21 October 2020

Our Ref: 20-0060swc3

Re: Art Gallery of NSW Expansion Project, Sydney Modern—Proposed Modification Landscape—Archaeological Assessment and Heritage Impact Statement

Sheet No.
LD_DA_00-02

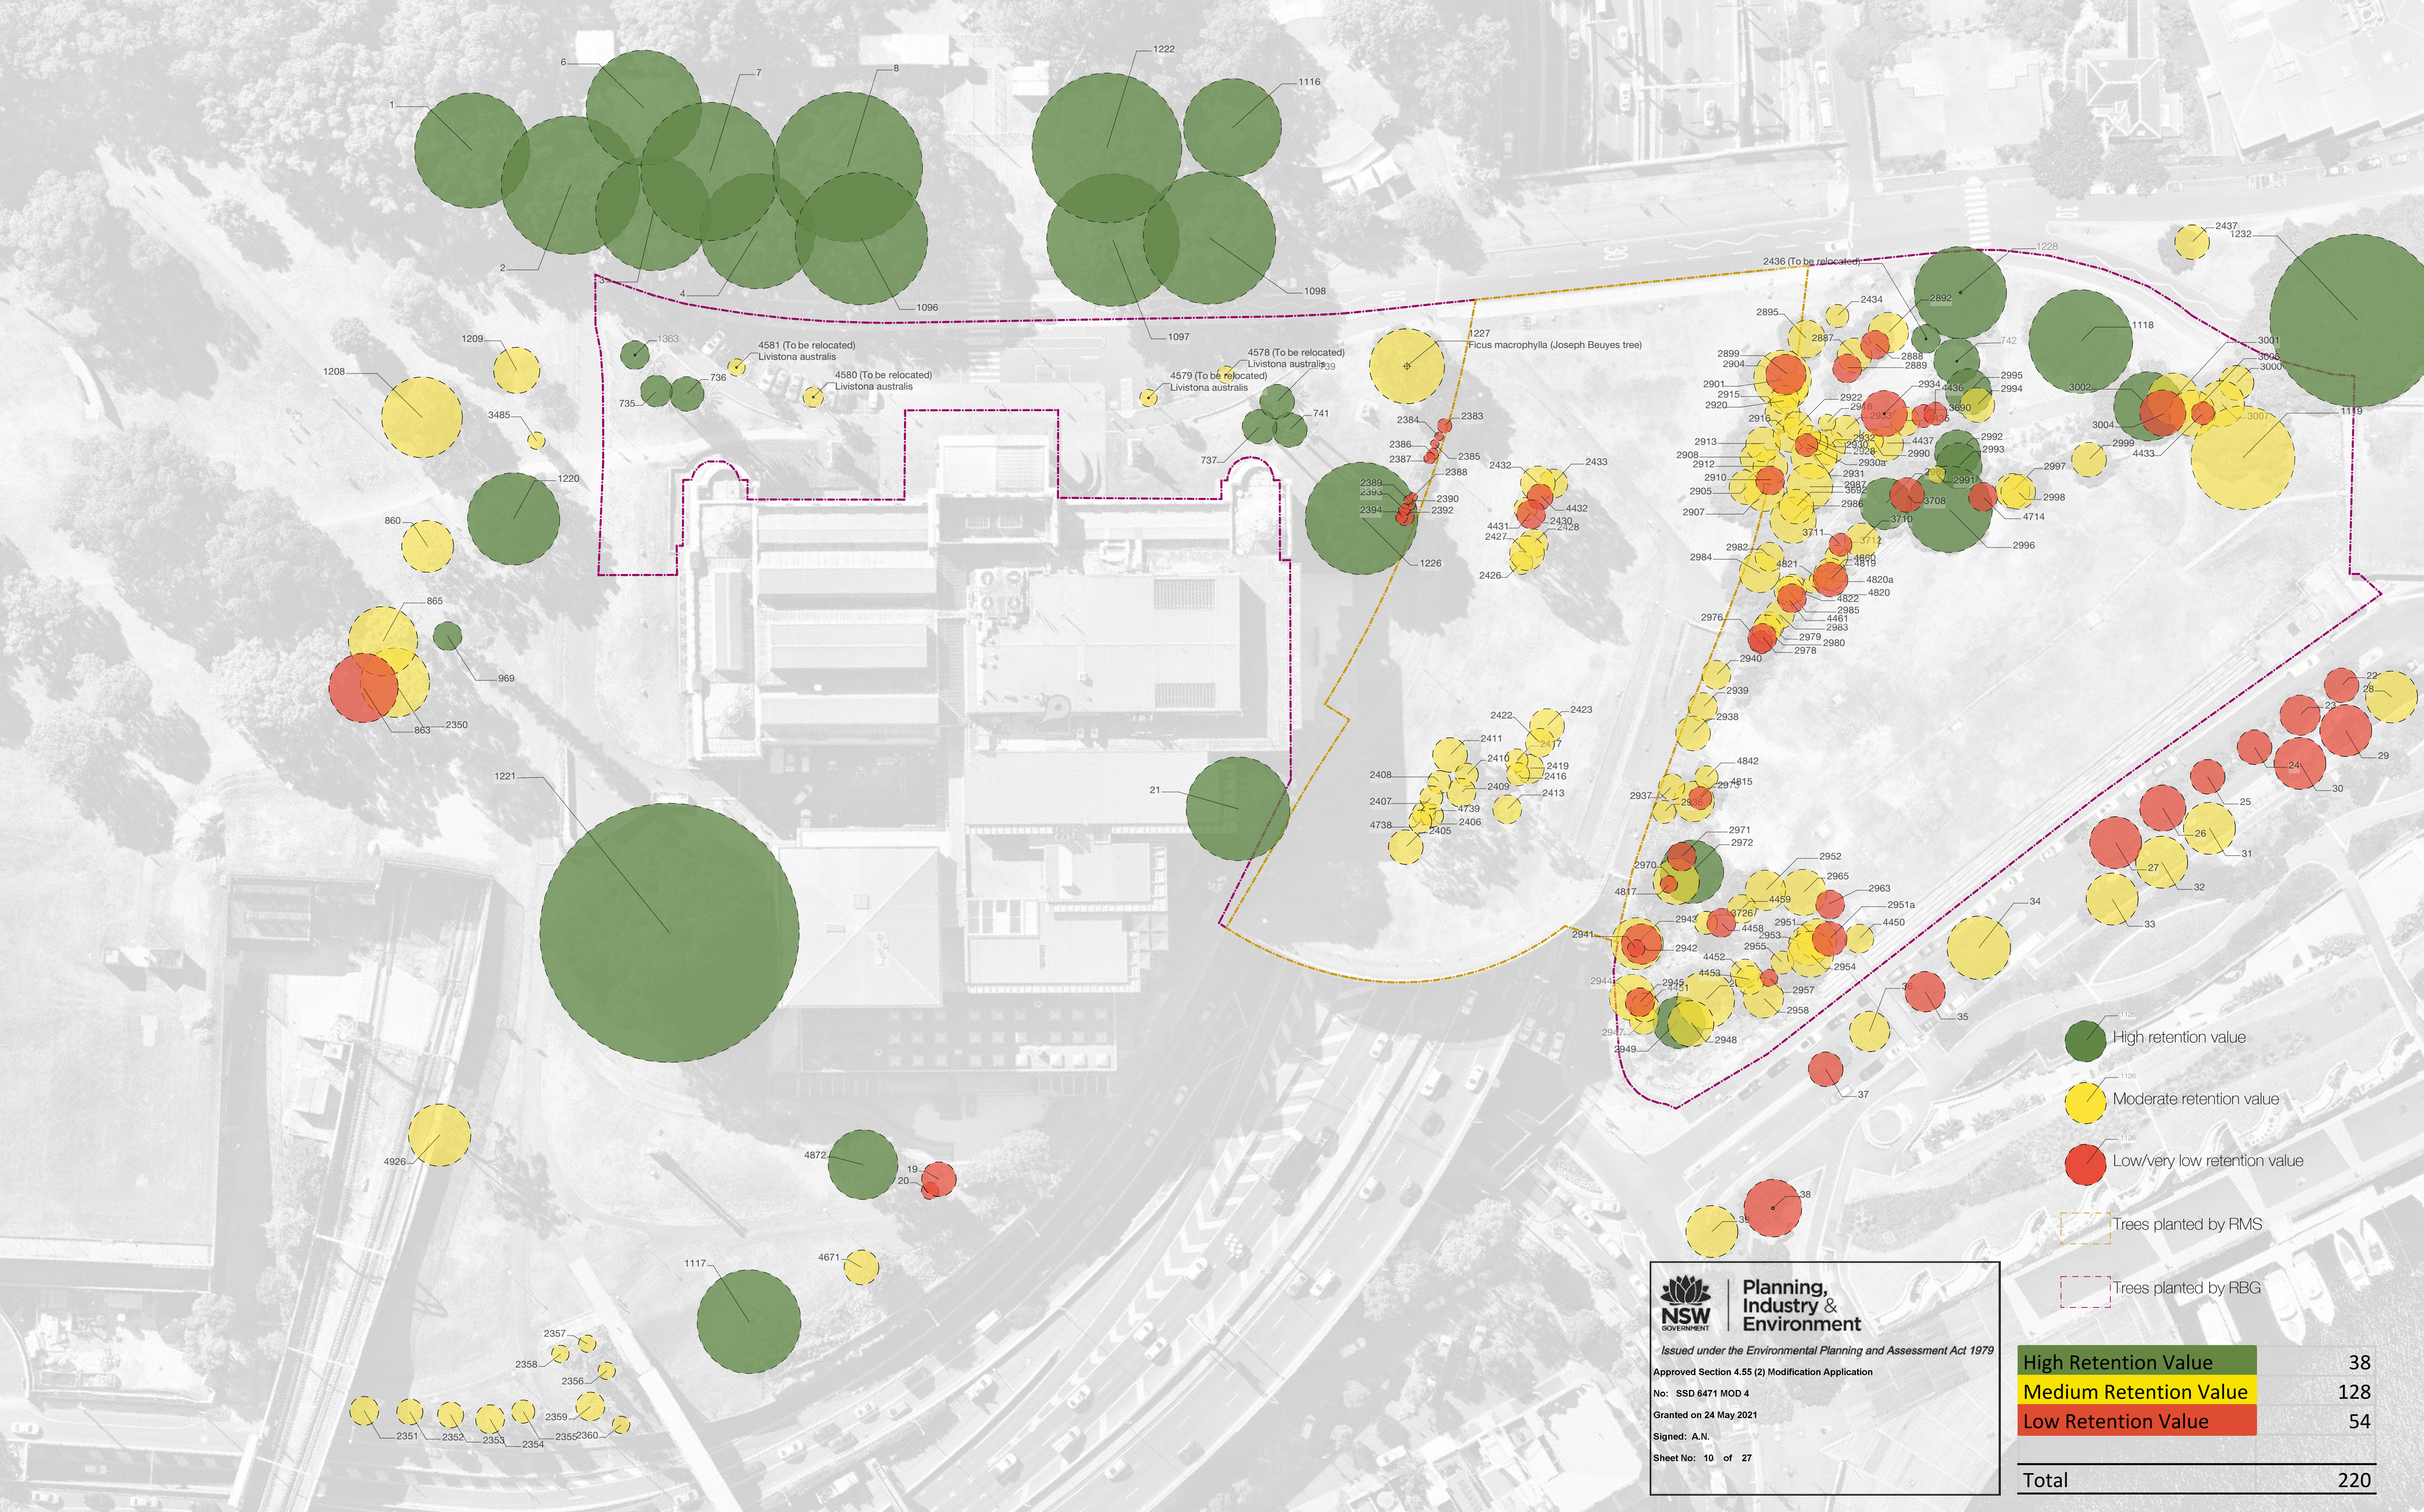
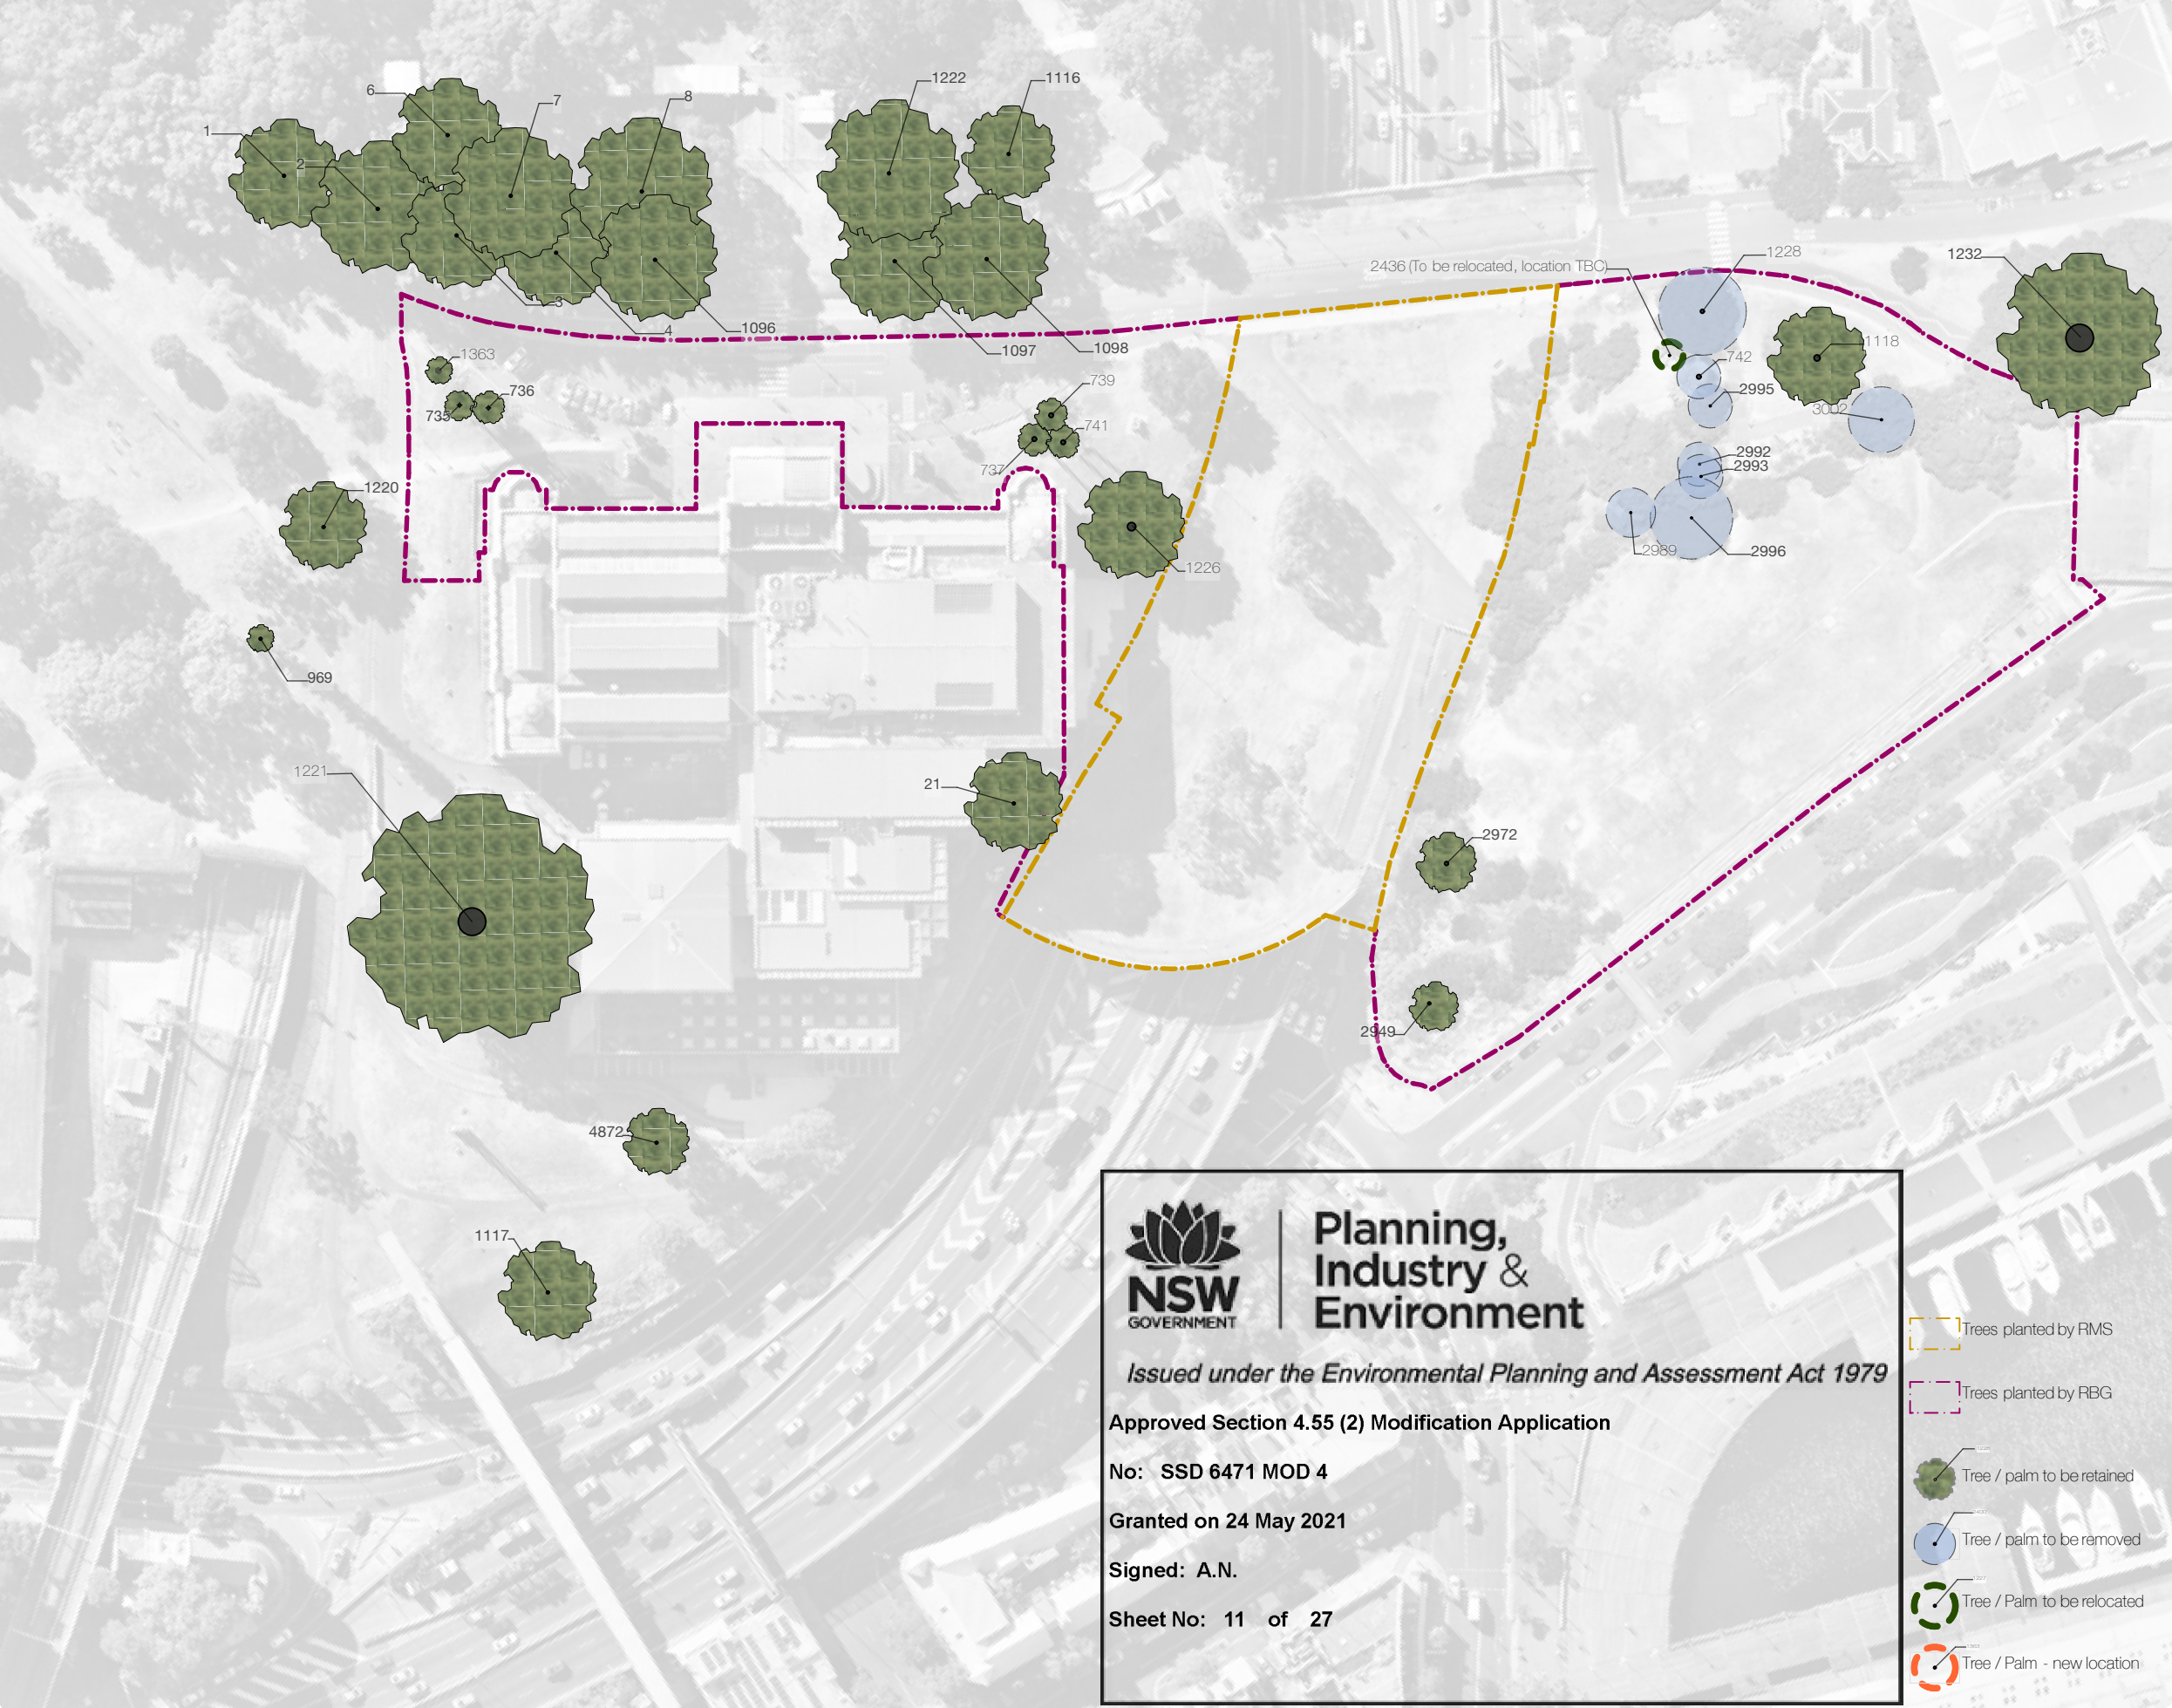
The existing Gallery building, and the landscape to its western elevation, is notable for its distinctive and formal geometry as well as the classical symmetry of the main elevation and its generally open character which allows full appreciation of the principal façade of the Vernon Wing. This open character is revealed on approach from the south by the heavily shaded and gently curved Art Gallery Road. The planting of 13 new red bloodwood trees (*Corymbia gummifera*) in front of the apsidal end bays of the principal façade of the Vernon Wing will significantly alter the historic—and current—open setting of the Vernon Wing. The number and density of the tree planting, their location and the height of the species at maturity (20–35m equivalent to between five and ten storeys) contribute to the visual intrusion. Significant views of the Gallery building on approach from both the north and south from Art Gallery Road would be altered by the proposed plan. The prominence of the original palm plantings would also be reduced by the new trees. The plantings of this species of tree in this location would be an adverse heritage impact on the building and its setting, and alternatives to this species and location should be considered with heritage advice.

The proposed modifications to the landscape design also include installation of new security features to the eastern side of Art Gallery Road, to the length of the existing Gallery forecourt. Depending on the scale, positioning and form of the bollards and retaining wall, proposed design modifications may lead to visual clutter in the existing open landscape around the Gallery. This may have a minor to moderate adverse heritage impact; however, this should be confirmed upon preparation of a detailed design for the proposed security measures and should be guided by heritage advice during development.

Refinement of the landscape design has also included the proposal to install two reflection pools to the west of the Vernon Wing. These pools, with a dual purpose of hostile vehicle mitigation and enhanced entry setting, would flank the axial approach to the entry steps to the central portico on the Gallery building. The rectangular pools would run on a north–south alignment, parallel to the Art Gallery building, and would sit above ground level. The pools would be a new addition to the historic setting of the gallery and details about the height required for hostile vehicle mitigation would need to be considered during detailed design development in order to avoid visual intrusion on the setting of the Vernon Wing. This should be guided by heritage advice during design development.

3. The details regarding the hostile vehicle management measures (including bollards and pools) and tree planting the forecourt of the Vernon Wing (the Vernon Curtilage) should be reviewed—particularly with regard to keeping views to the Wing from the north and south as open and uncluttered as possible.

5. If trees are functionally essential in the forecourt, further investigation should be undertaken to select a species with a lower and more open habit. The location of individual trees should also be reviewed to minimise view impacts.

6. The proposed concrete retaining walls adjacent to Art Gallery Road should be reviewed in detail to confirm they are compatible with the significant elements and landscape setting of the Vernon Wing.

Sheet Title
Vernon Curtilage

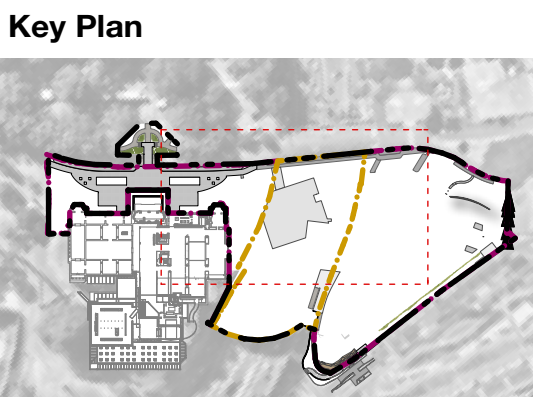
The sandstone dwarf wall in front of the existing Gallery is identified as a significant element within the setting and landscape of the Art Gallery. Previously, this wall was used to demarcate the carriage loop leading to the entrance of the Vernon Wing. However, over the course of minor modifications to the forecourt the wall has been realigned in sections and has been accompanied by the building up of ground

levels over the years. The approved landscape design included demolition of elements of the sandstone wall to ground level. The proposed modifications to the landscape design now propose for the sandstone wall to be retained and relocated largely to its original alignment. This will require the sandstone wall to be removed in sections, raised and realigned as part of the overall modifications to the forecourt. The change in level for the sandstone wall will minimise the trip hazard of the wall, while also increasing the prominence of this element in the landscape. This proposed modification to the design would have a minor positive heritage impact, through the reinstatement of a significant element to a more prominent position and reset with reference to its previous, original alignment.

The proposed design modifications to the forecourt of the Vernon Wing (the Vernon Curtilage) includes elements that retain and reveal the heritage significance of the place such as the serpentine dwarf wall’s reconstruction and the removal of the stark parking area. However, elements of the design of the forecourt—principally hostile vehicle management measures and the addition of potentially very tall groves of trees—would change the historic setting and may interrupt some key views to the existing gallery, thereby having potentially adverse impacts on the heritage values of the existing gallery.
